Application for Planning Permission for Works or Extension to a Dwelling

Development: Two storey side extension following demolition of existing garage, alterations to fenestration and vehicular crossover.

Location: 23 Pinewood Gardens Bognor Regis PO21 2XB

EXISTING ELEVATIONS

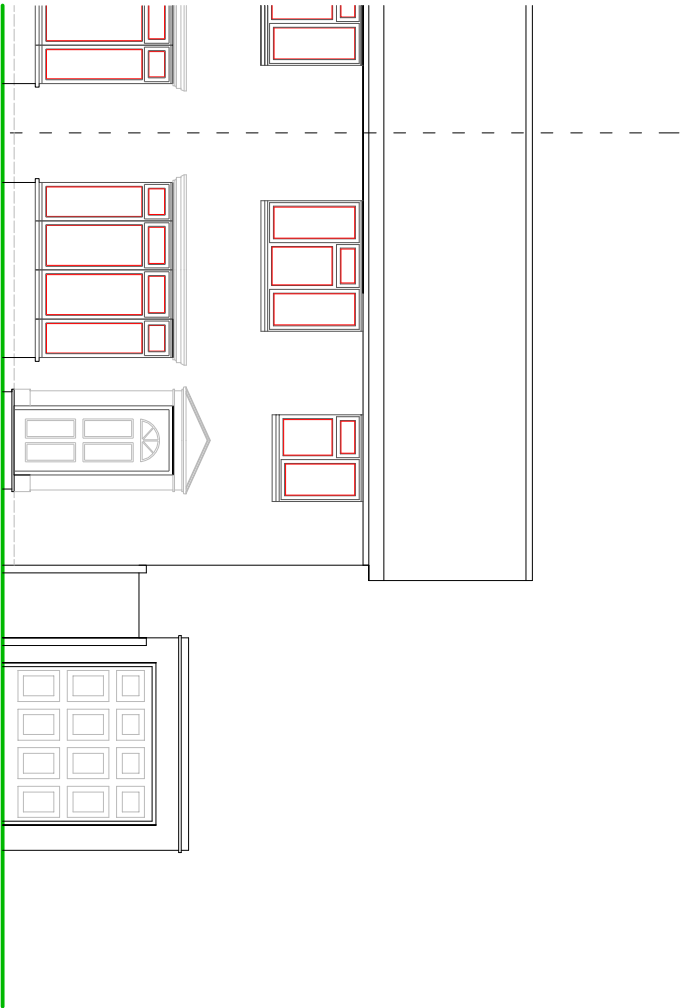
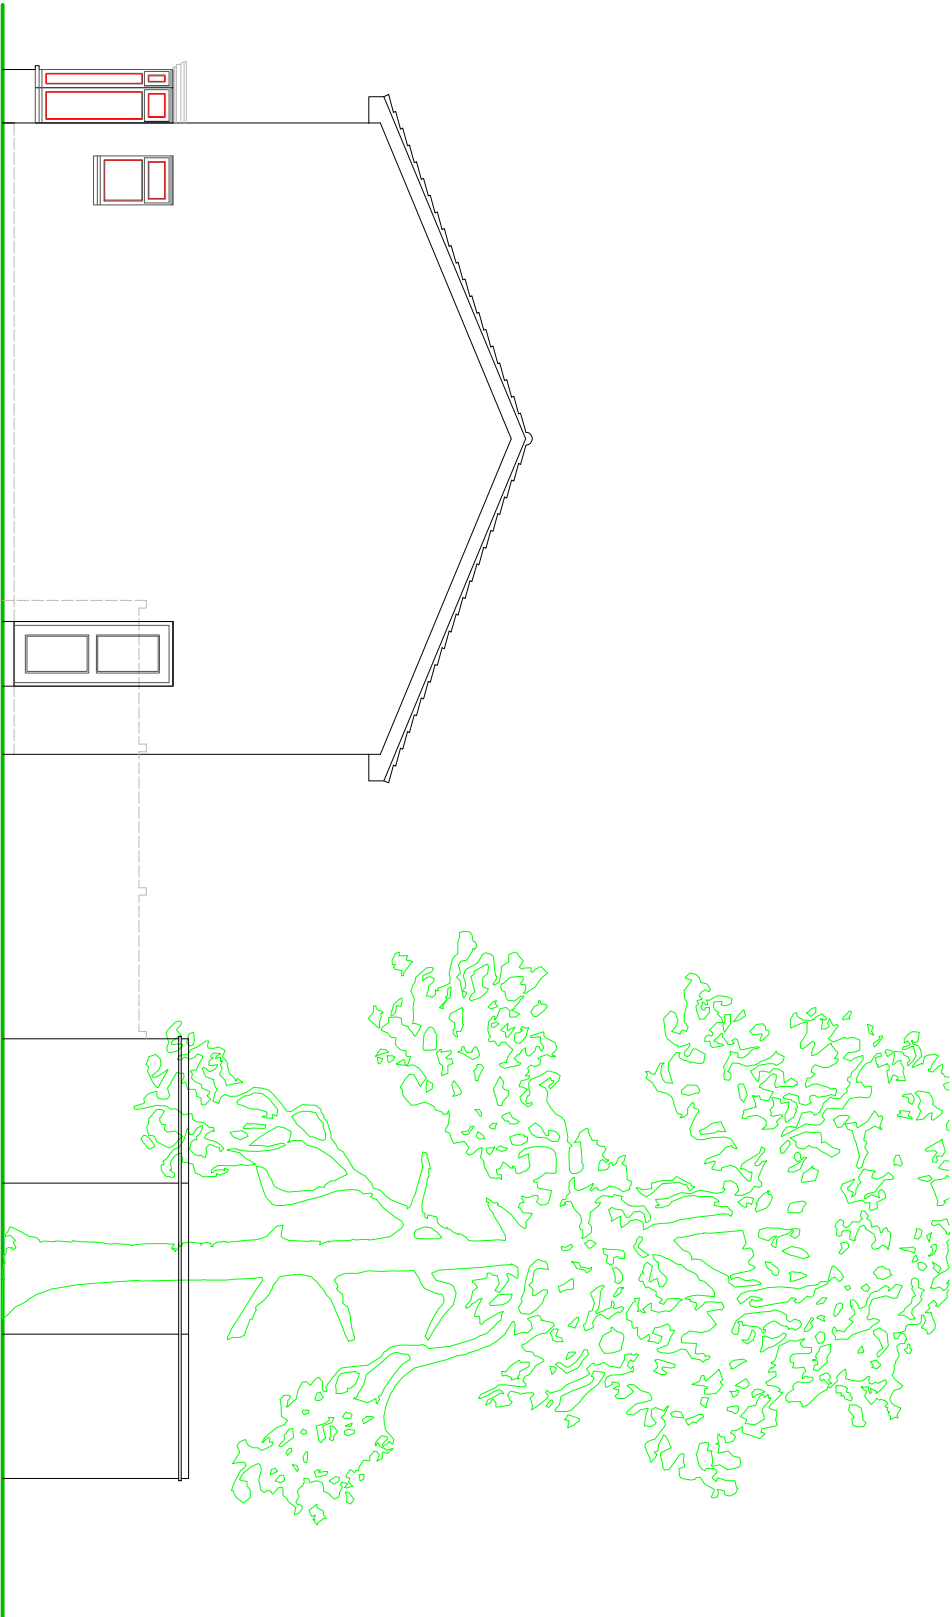
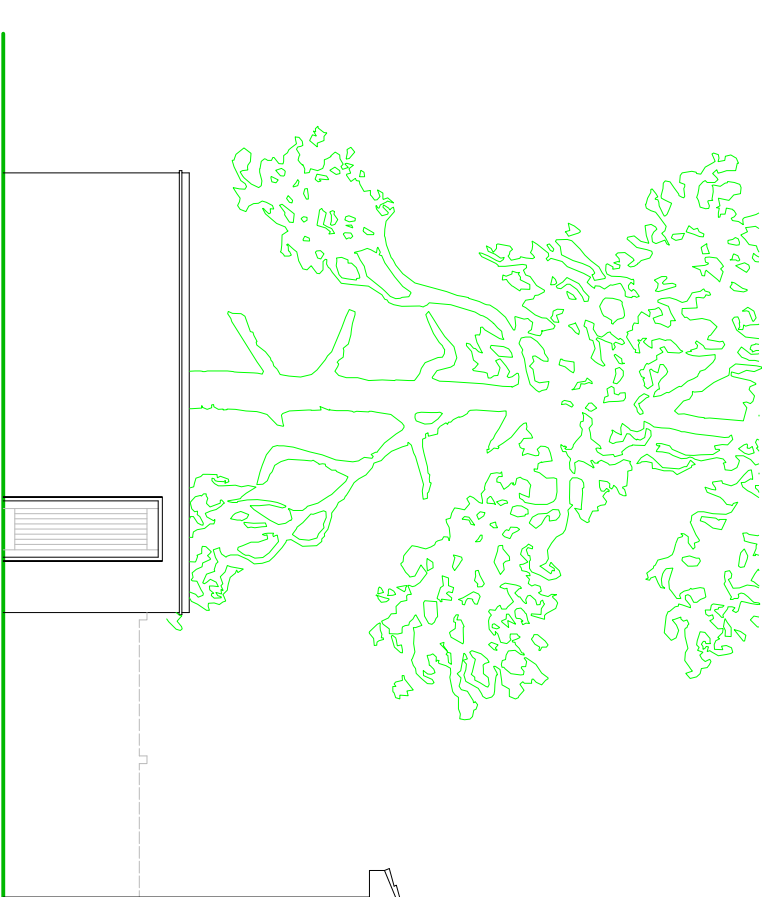
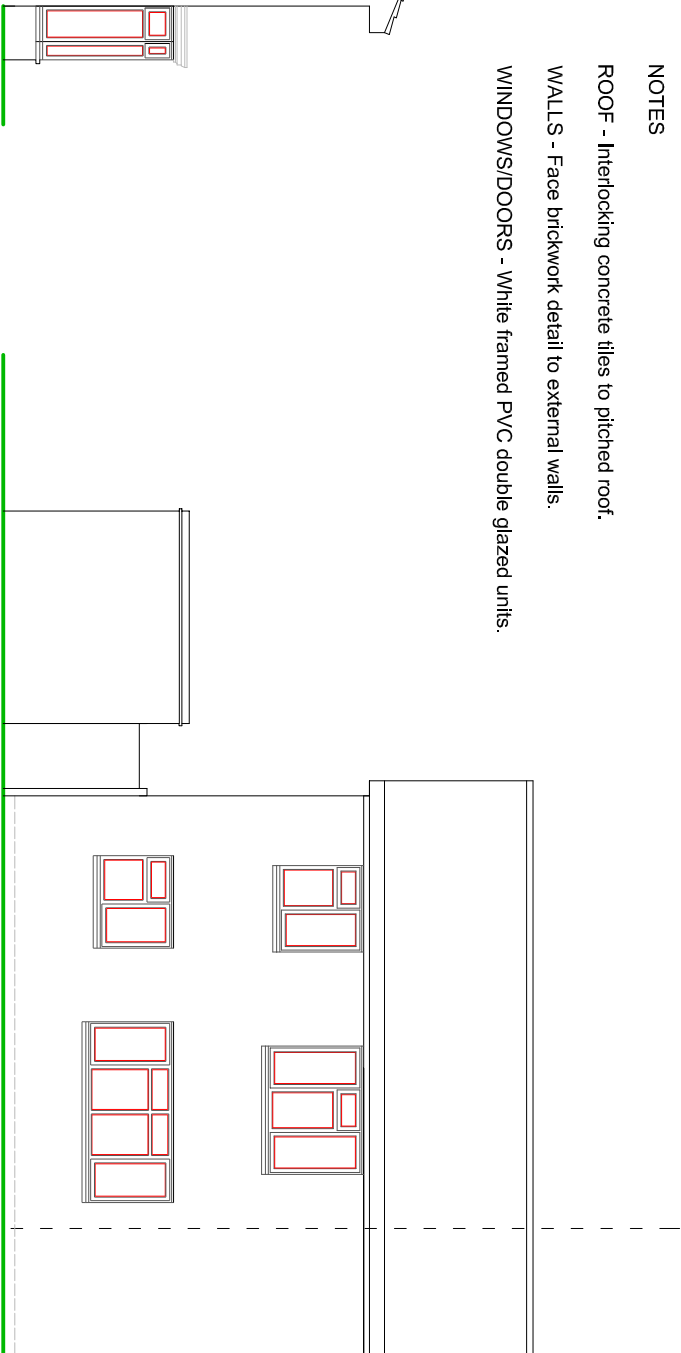
Elevations

Please provide existing and proposed elevations of the wall that is to be shortened.

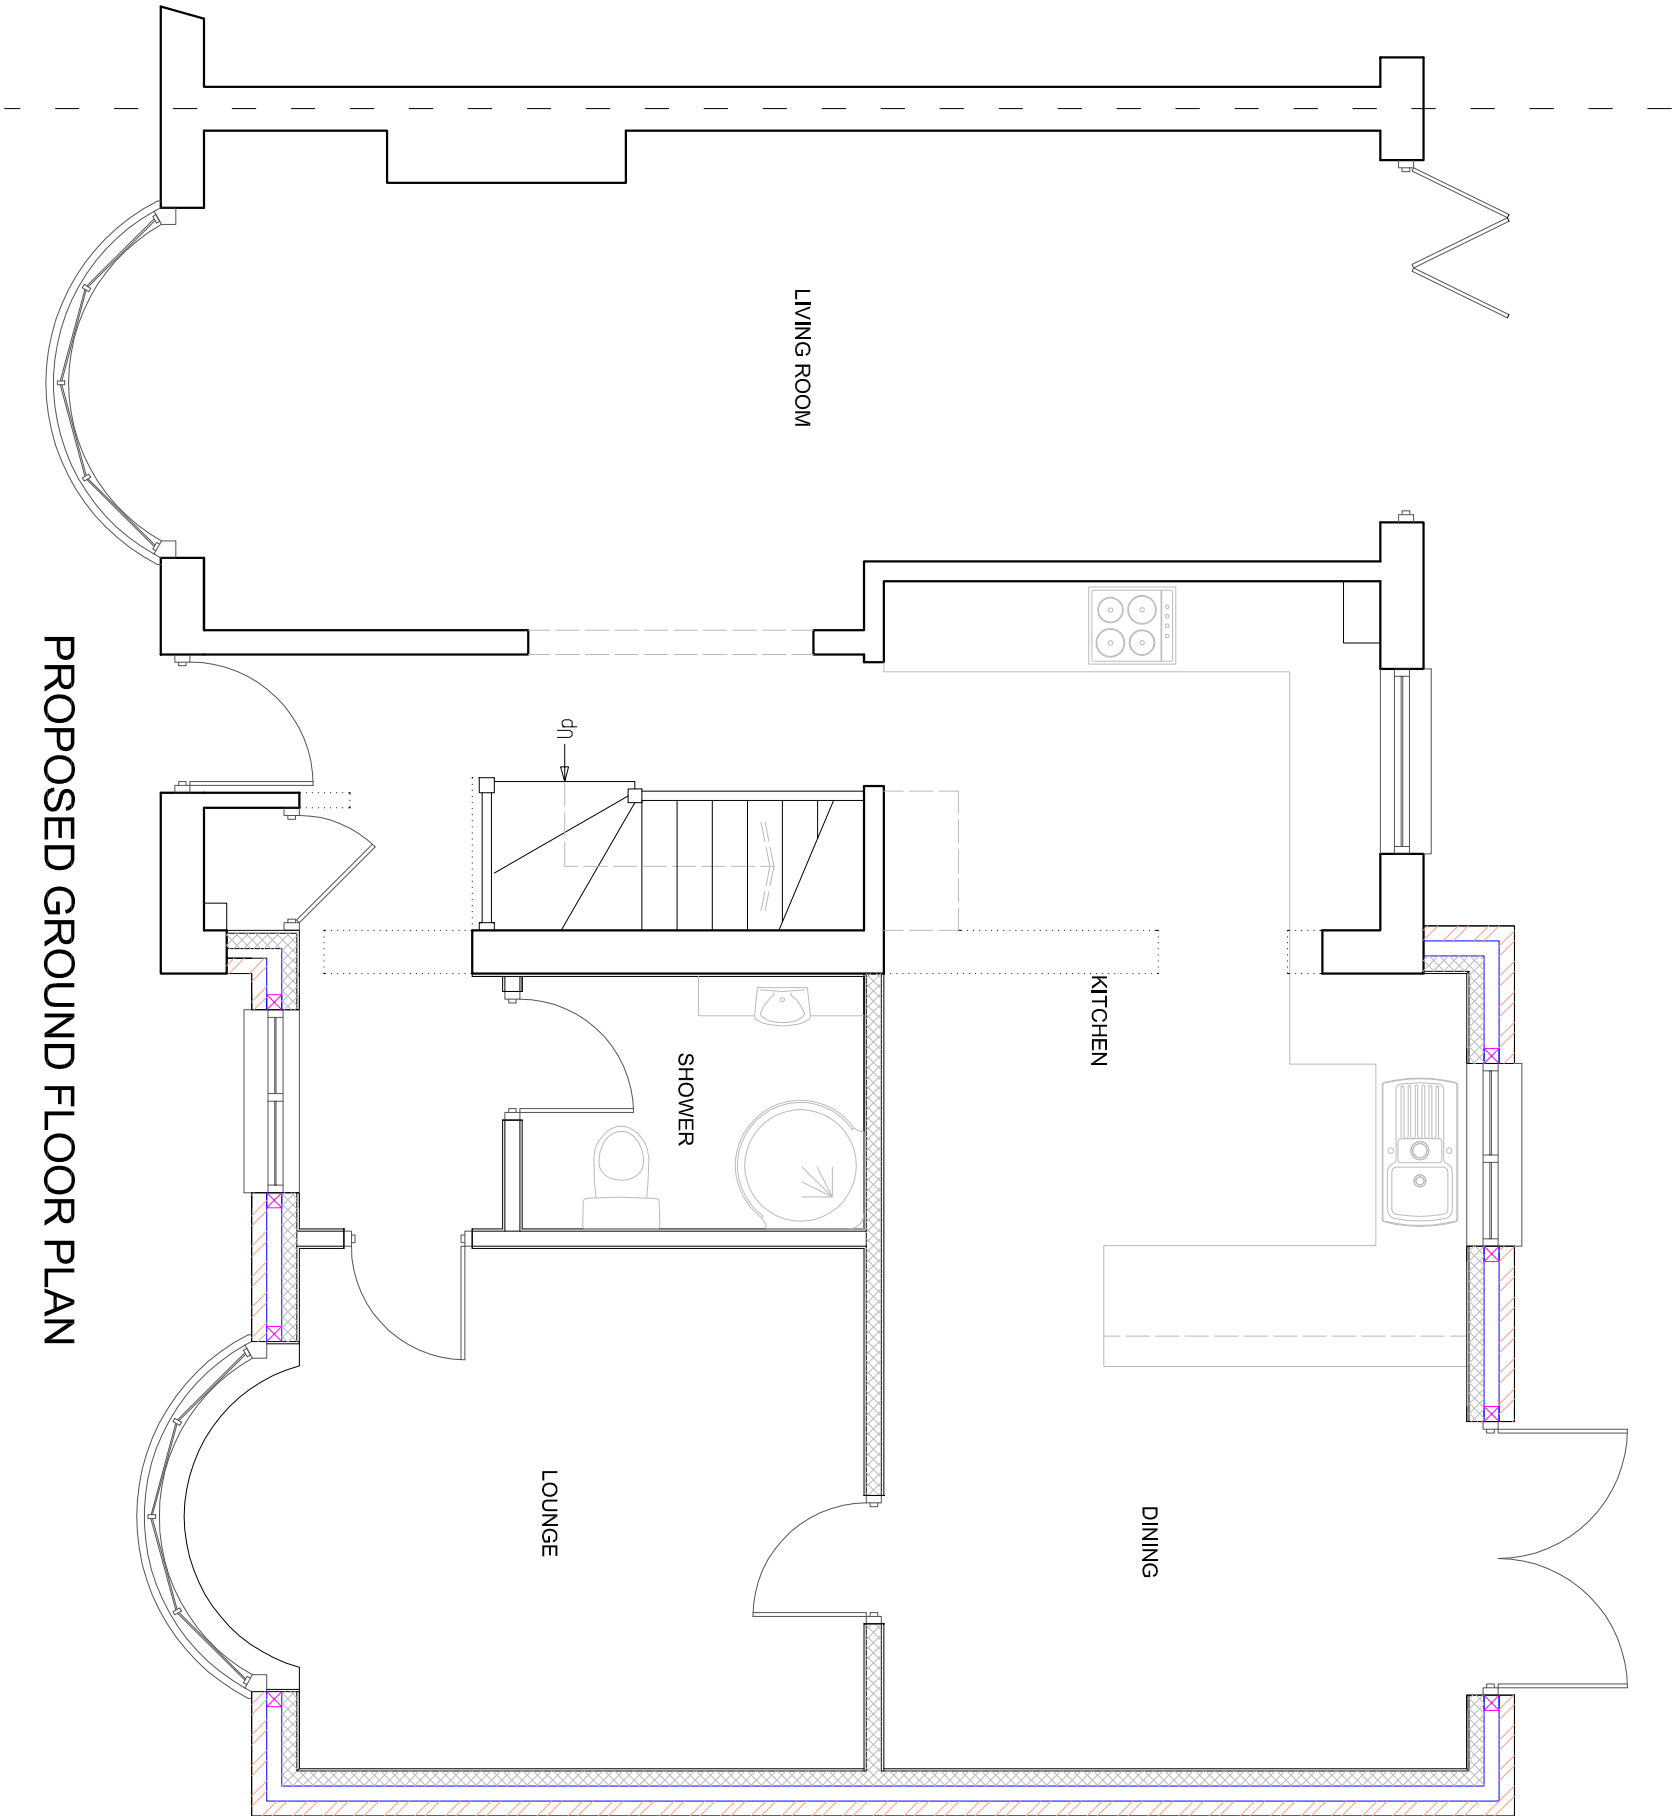
Crossover

You are required to submit a scaled plan of the crossover showing the width and depth of the proposed crossover.
